## RE: Aspect Industrial Estate Modification 2 – SSD 10448 Proposed Mod 2 – Response to Submissions

We refer to the relevant submissions received in relation to the aforementioned State Significant Development (SSD-10448-Mod-2<sup>1</sup>). Reference is made to the submissions by Penrith City Council (Council, dated 24 August 2022). A summary of the relevant traffic and access comments, and the Ason Group response is provided below.

**TABLE 1: RESPONSE TO COUNCIL COMMENTS**

| WAREHOUSE 1 | |
|------------------|-----------------------|
| Carpark Provided | 141 |

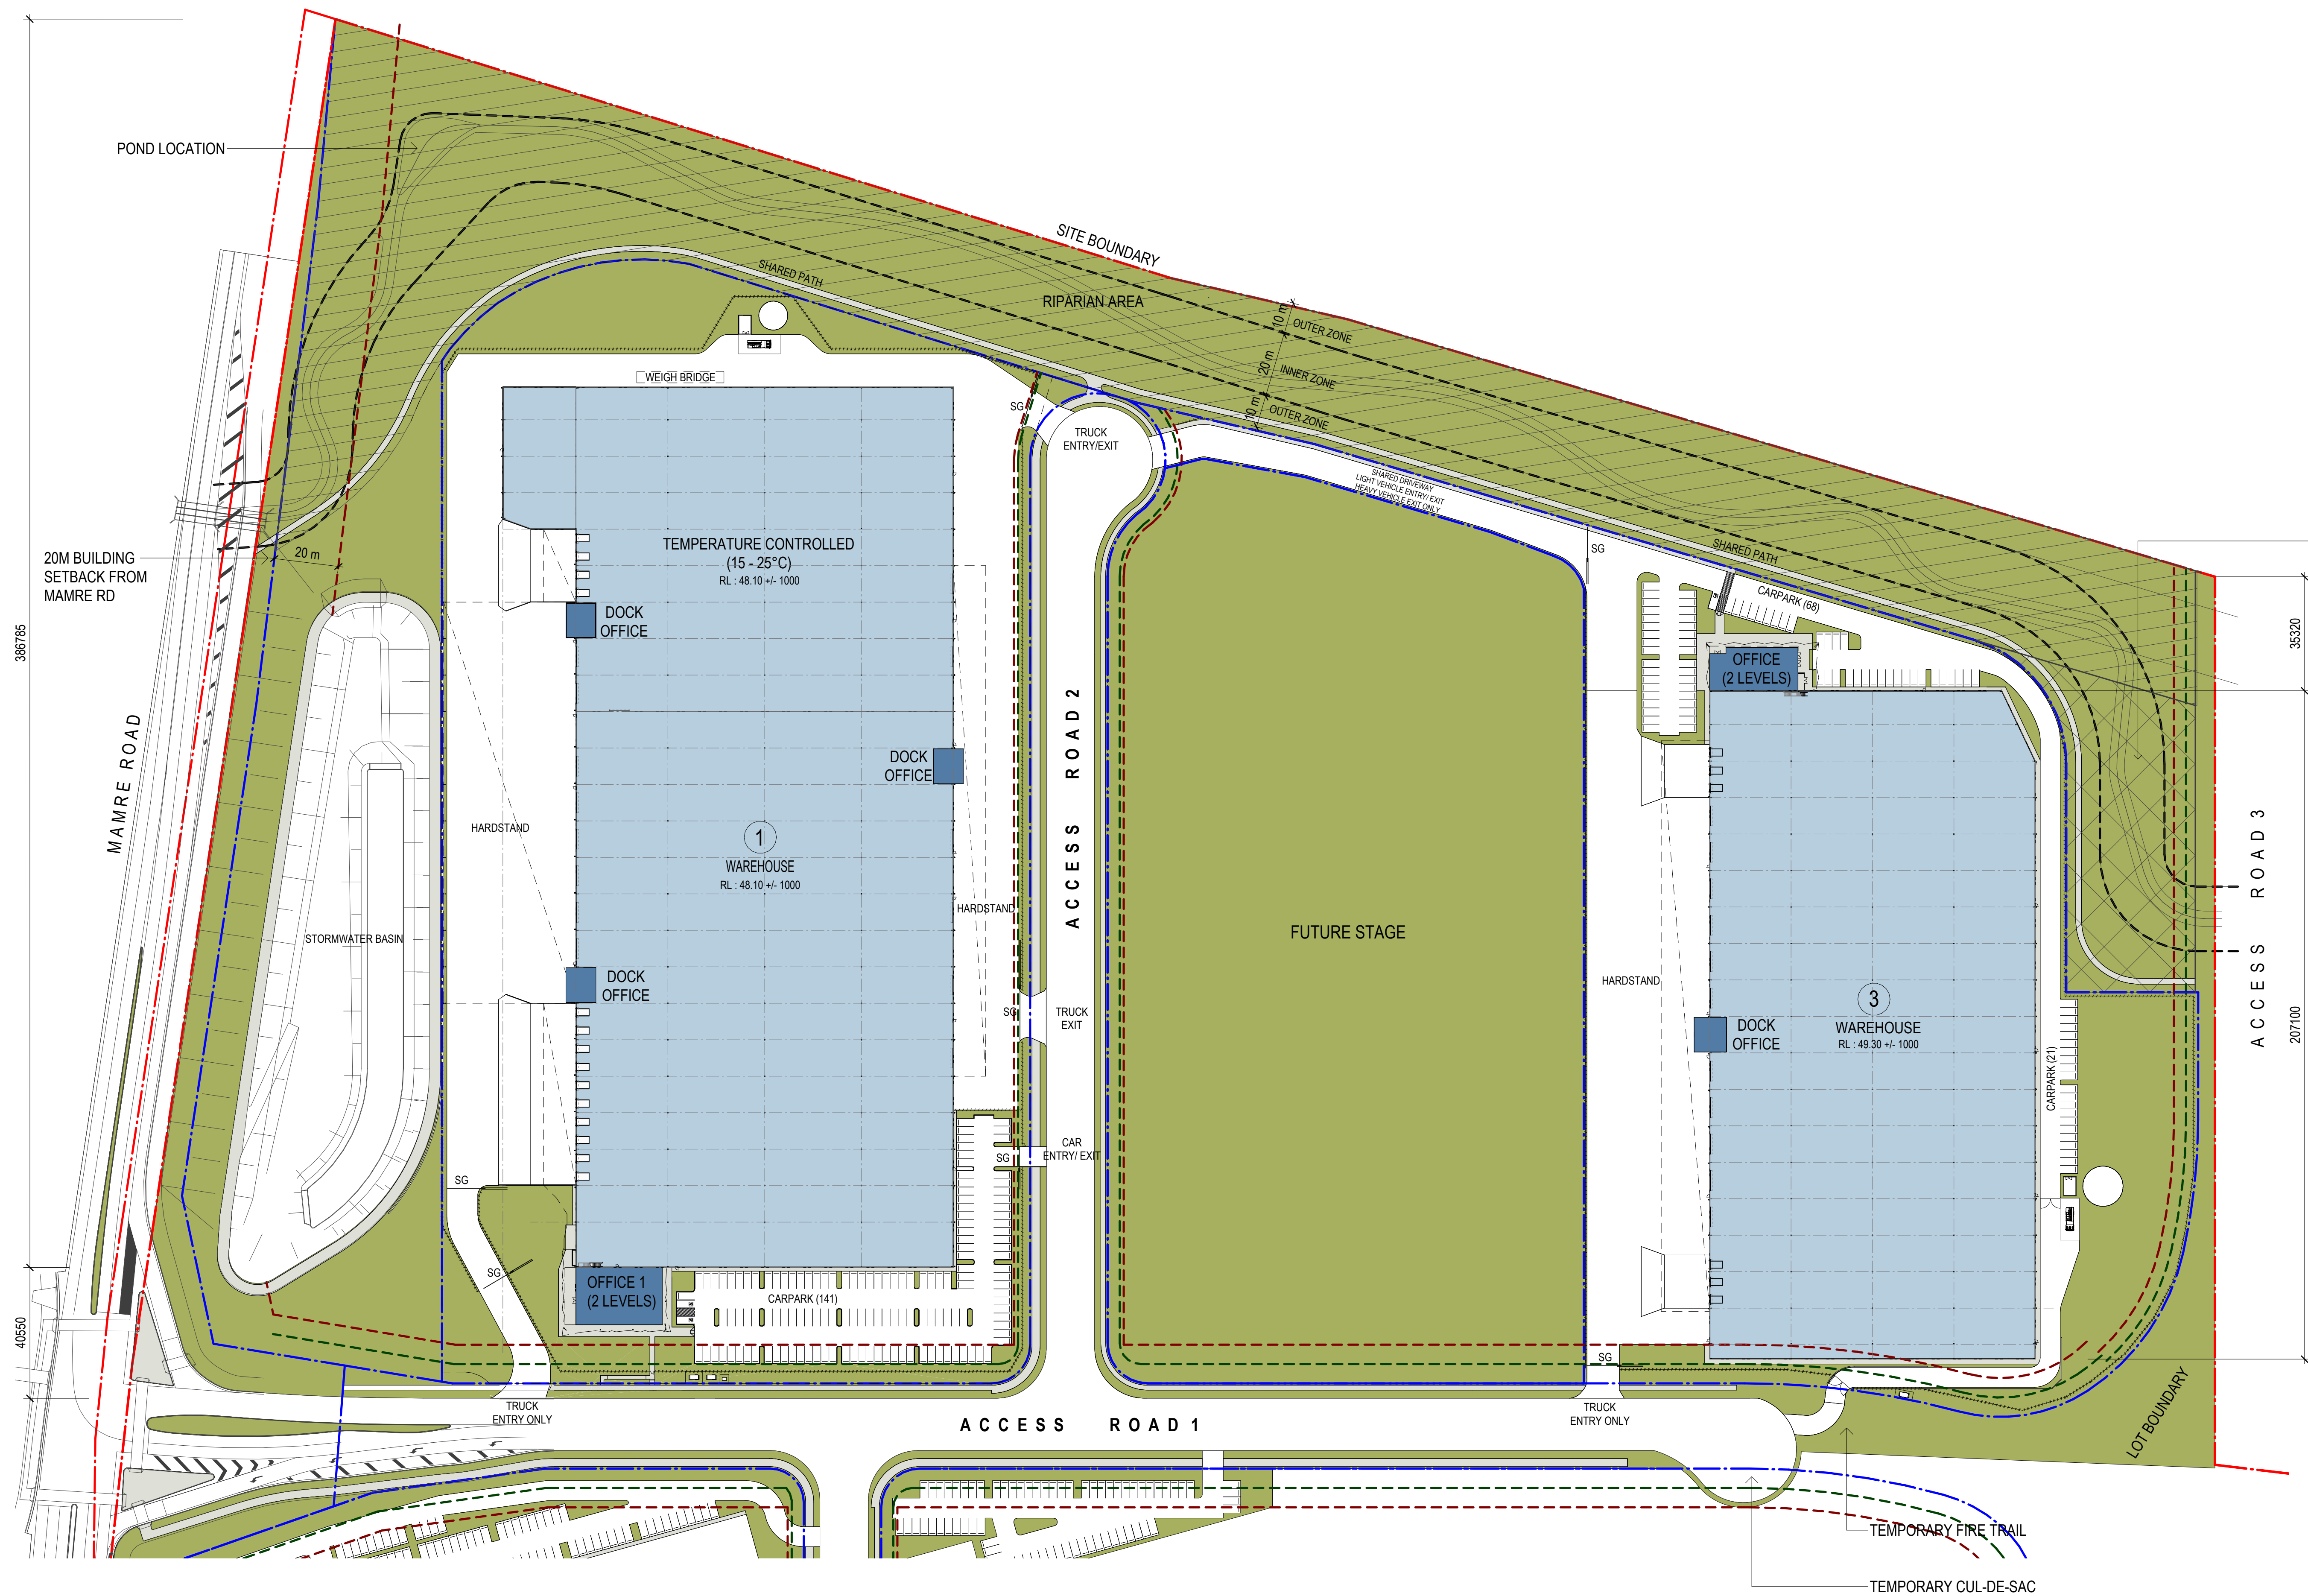
<p>The proposed internal circulation roadways for Warehouse 3 shared between passenger vehicles accessing the carpark and heavy vehicles accessing the hardstand this is not supported on safety grounds.</p> <p>Swept path assessments were not included in the Appendix of the updated traffic report and in this respect DPE should request and review.</p>	<p>As above, see response to <b>Item 2 (b)</b>.</p>

<p>The shared driveway will be for truck exit only. The flow through the hardstand will be line marked and signposted accordingly to ensure no heavy vehicles utilise this point to enter the Site. Further, at the internal point of exit from the hardstand to the driveway, “stop” line marking and signage is to be provided to ensure that light vehicles exiting the car park have priority.</p> <p>This will form part of the signage design requirements, which is detailed prior to the occupation. It is anticipated that this could be ensured via a suitable Condition of Consent, to be prepared by a suitably qualified consultant during detailed Construction Certificate design coordination.</p> <p>Further to the above, a minor change has been made to layout, to ensure that the exiting heavy vehicle would not cross over the centre of the driveway. Thus, therefore would be no conflicts between light and heavy vehicles.</p> <p>Swept path analysis for Warehouse 3 on the updated masterplan is annexed in <b>Appendix A</b> (see Sheet AG06).</p>
